CITY OF ALBUQUERQUE
PLANNING DEPARTMENT
DEVELOPMENT REVIEW BOARD

September 14, 2005

Project # 1002321
05DRB-01333 Major-SiteDev Plan BldPermit

BOHANNAN HUSTON agent(s) for MASTHEAD ROAD DEVELOPMENT LLC request(s) the above action(s) for all or a portion of Lot(s) 11, **JOURNAL CENTER PHASE 2, UNIT 2**, zoned IP, located on RUTLEDGE RD NE, between MASTHEAD NE and BARTLETT NE containing approximately 10 acre(s). (D-17)

**PRELIMINARY PLAT**  
APPROVED BY DRB  
ON 9/14/05

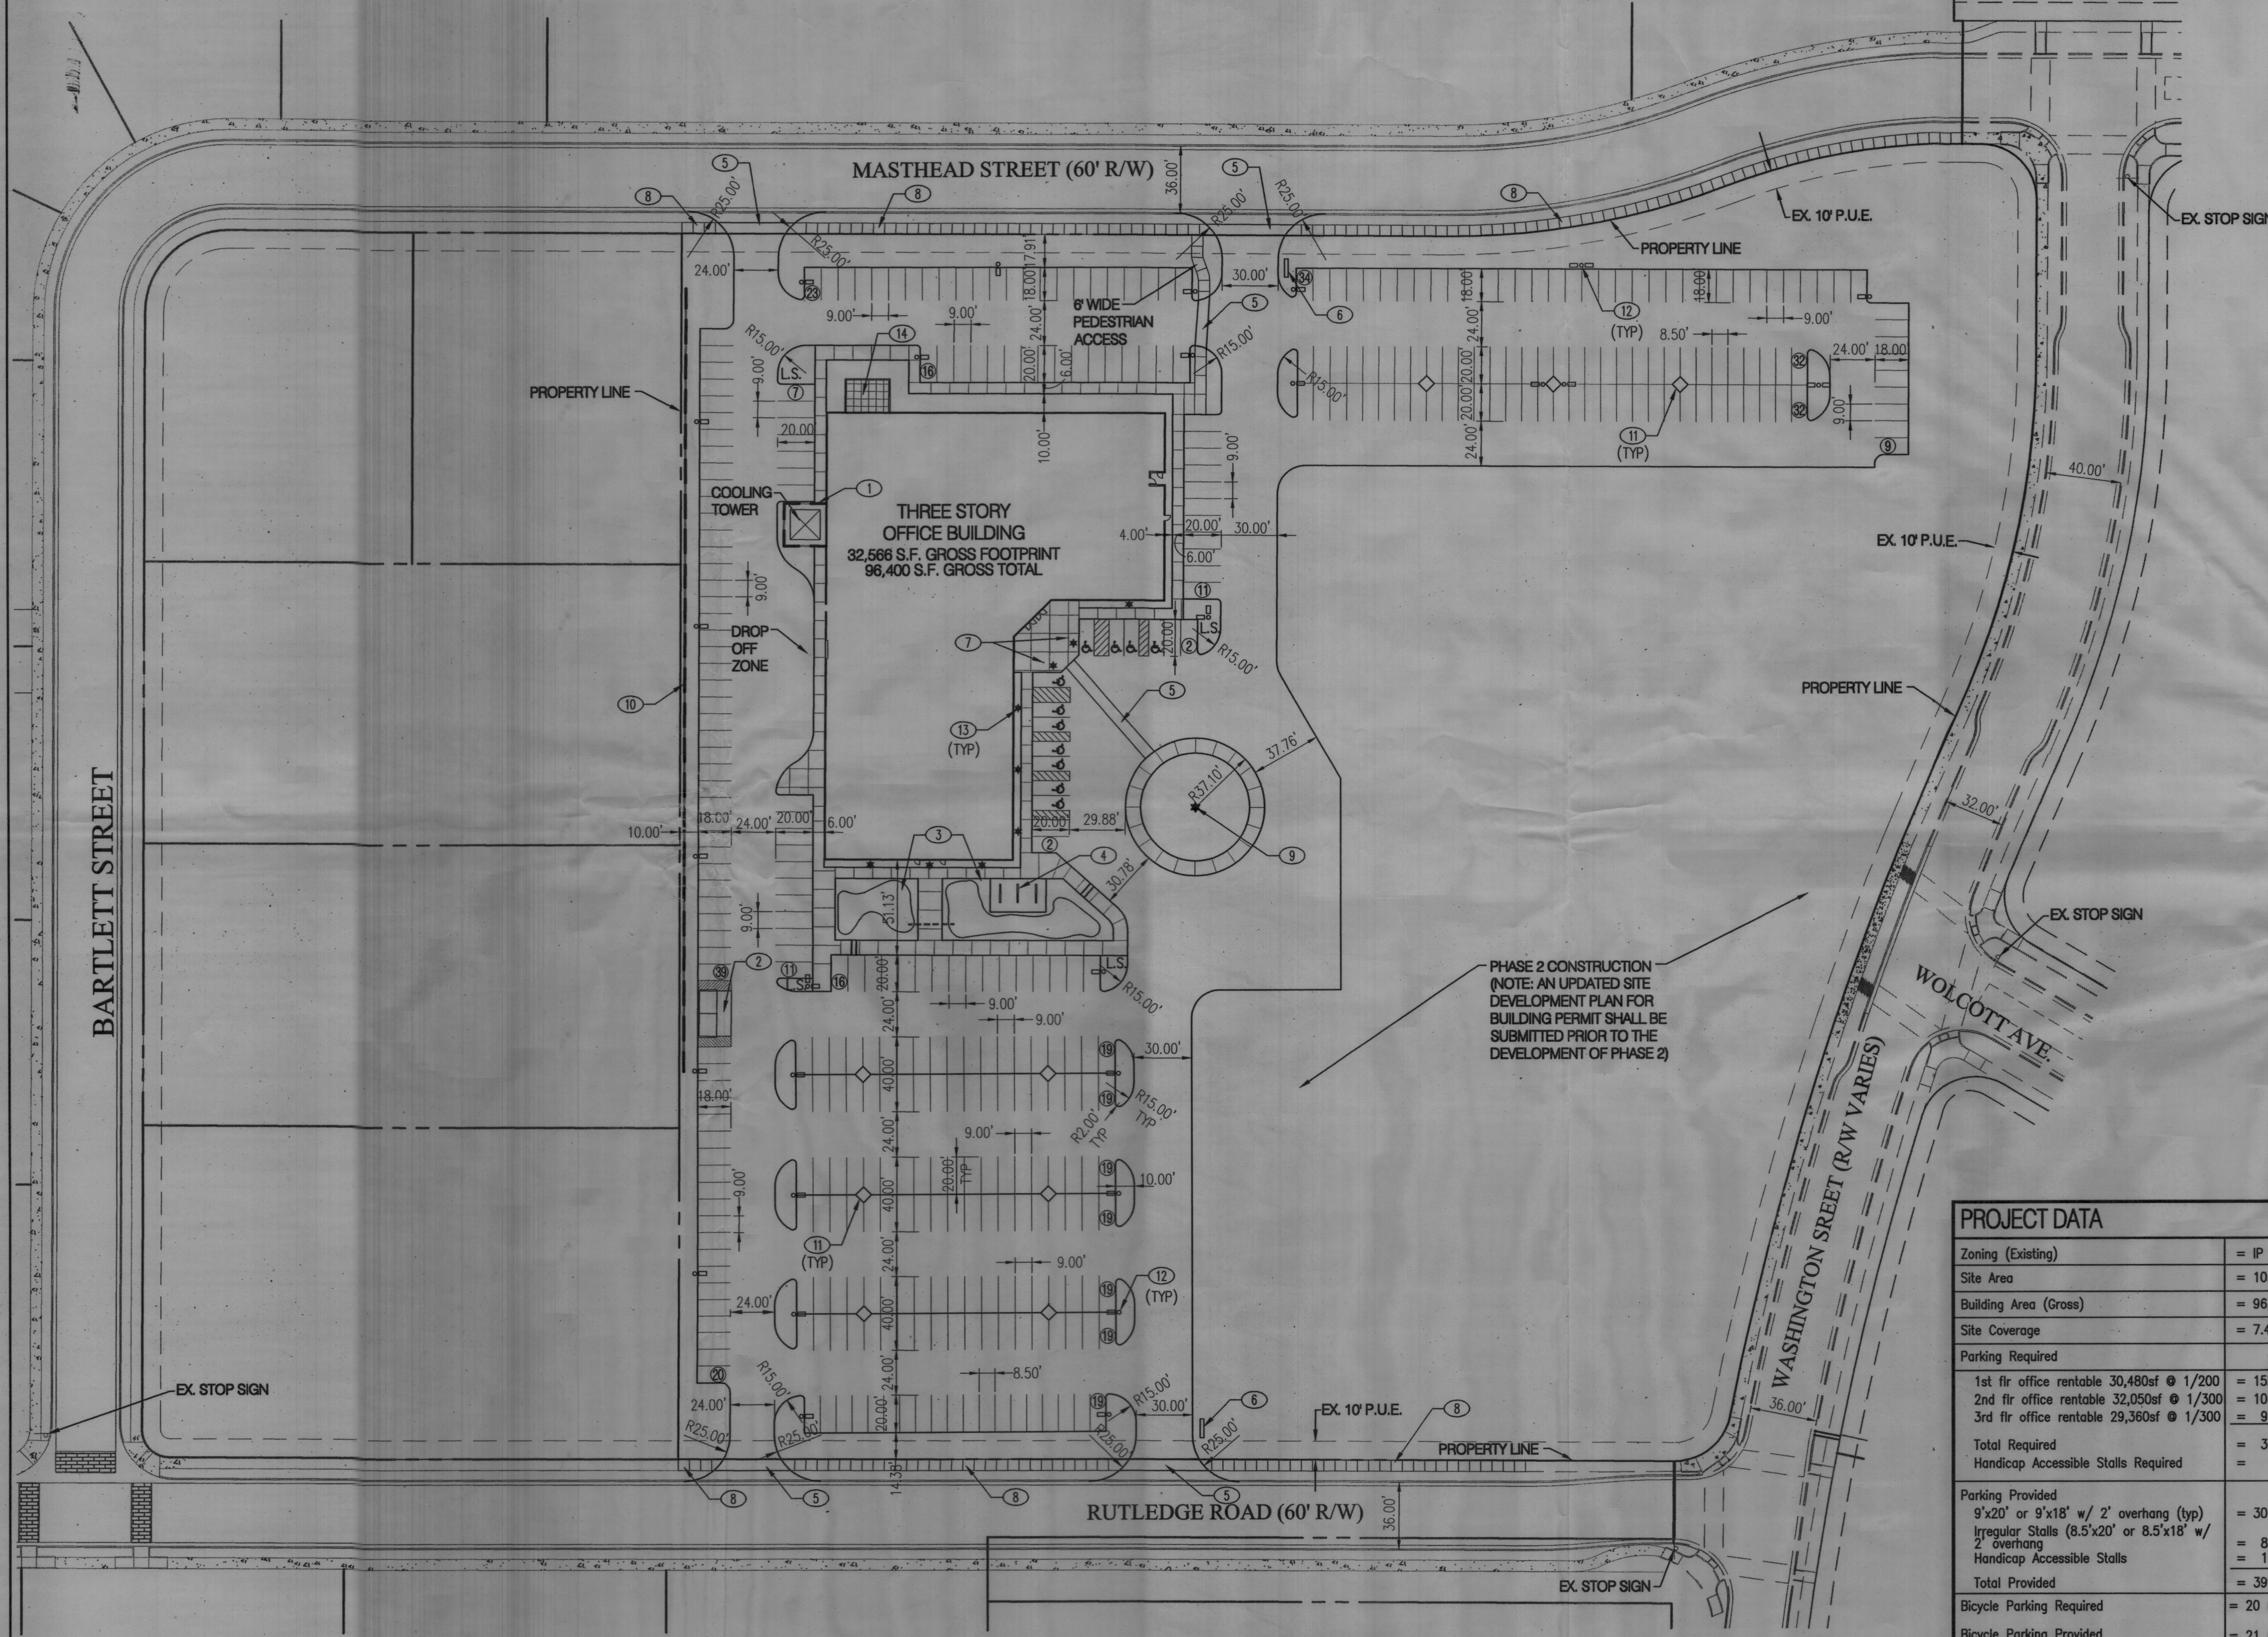
Ensure that the sight lines for transportation can be met with the proposed landscape plan. Where are the build notes for the entrances? How do these line up with entrances across the street? What is the status of the trip generation comparison? Bumpers are needed to prevent encroachment onto the 6' sidewalk. Is the sidewalk being extended on Rutledge to the existing sidewalk?

✓ The Journal Center Site Plan Approval language should appear on the site plan page just above the DRB signature block. However, the signature line for the Planning Director is not necessary.

✓ The employee patio has trees for shade. Please add a note to the site plan indicating there will be tables and benches or chairs as well.

USDA FOREST SERVICE  
JOURNAL CENTER II  
LANDSCAPE PLAN

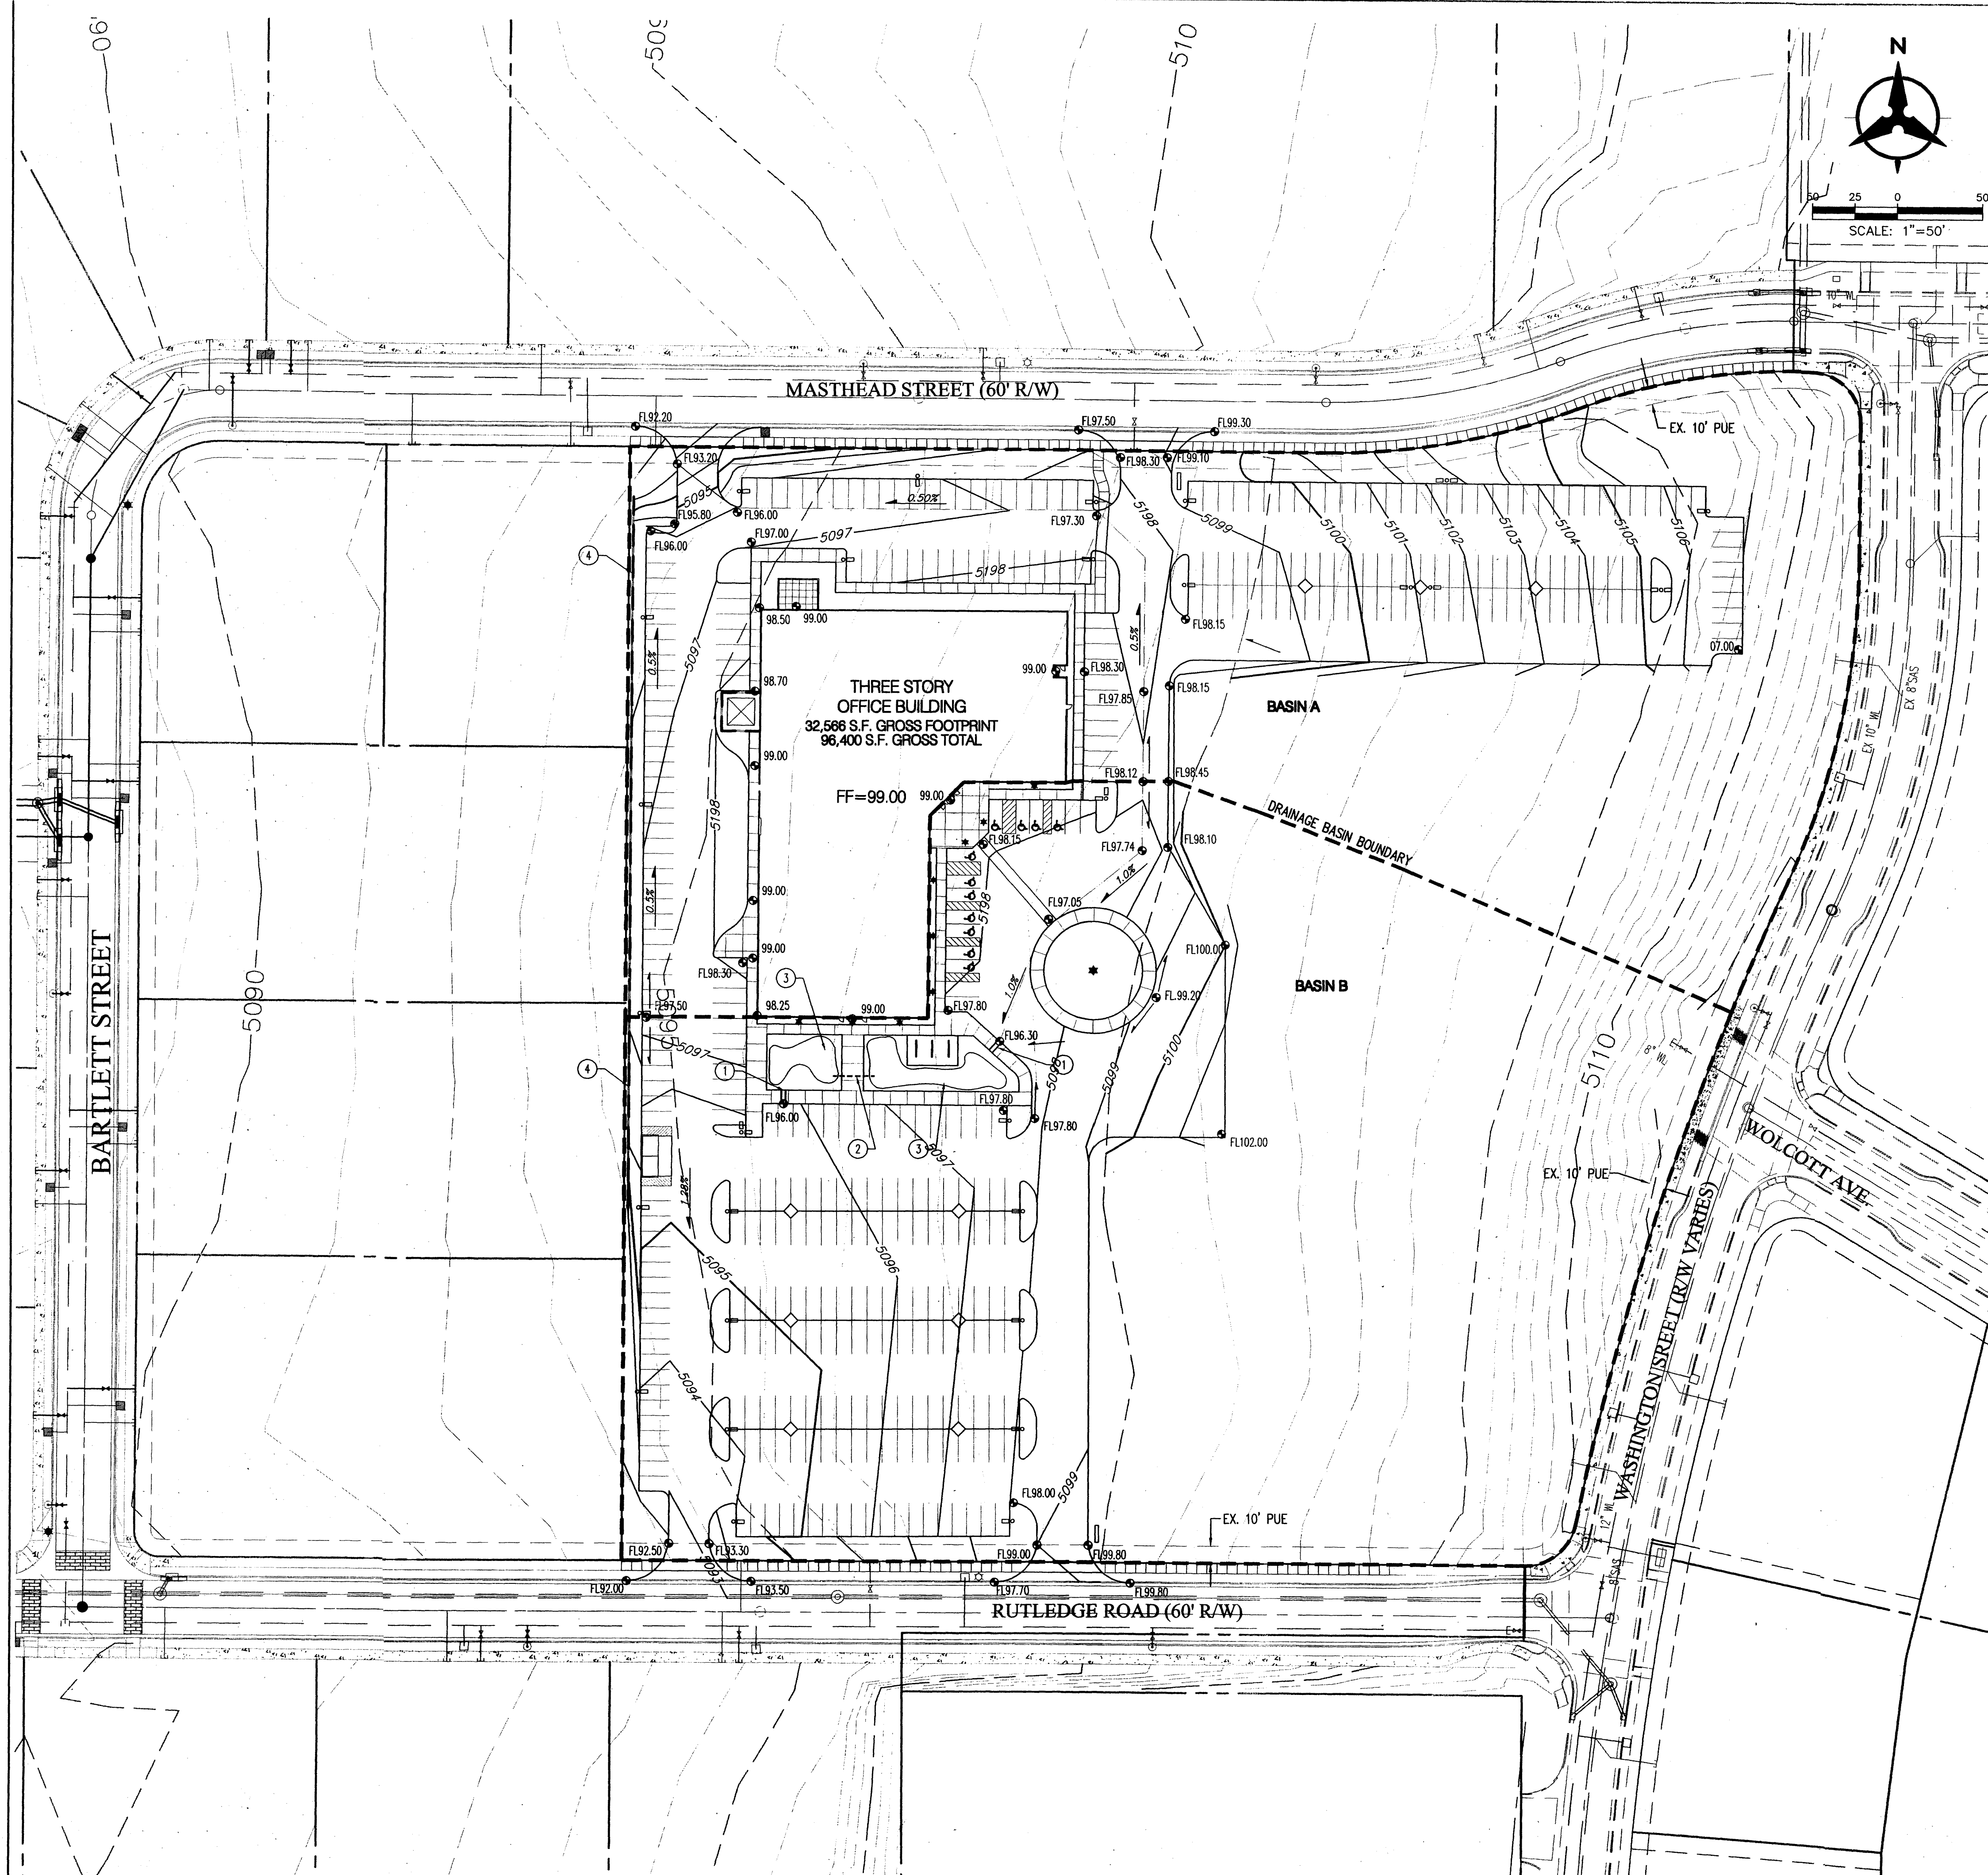
✓ Landscape Plan: The Berinda Ash is a high water use tree as indicated. With Albuquerque's water conservation priority, an additional 43 of these trees at this site is excessive. Please propose another tree with less water demand. It is possible to design a street tree scheme with 2 less water use trees mixed with the Berinda Ash, for example.

✓ Landscape Plan: The total landscape square footage is given but not the % as required. Santa Ana Tan gravel is specified but the depth is not given (3" for example).
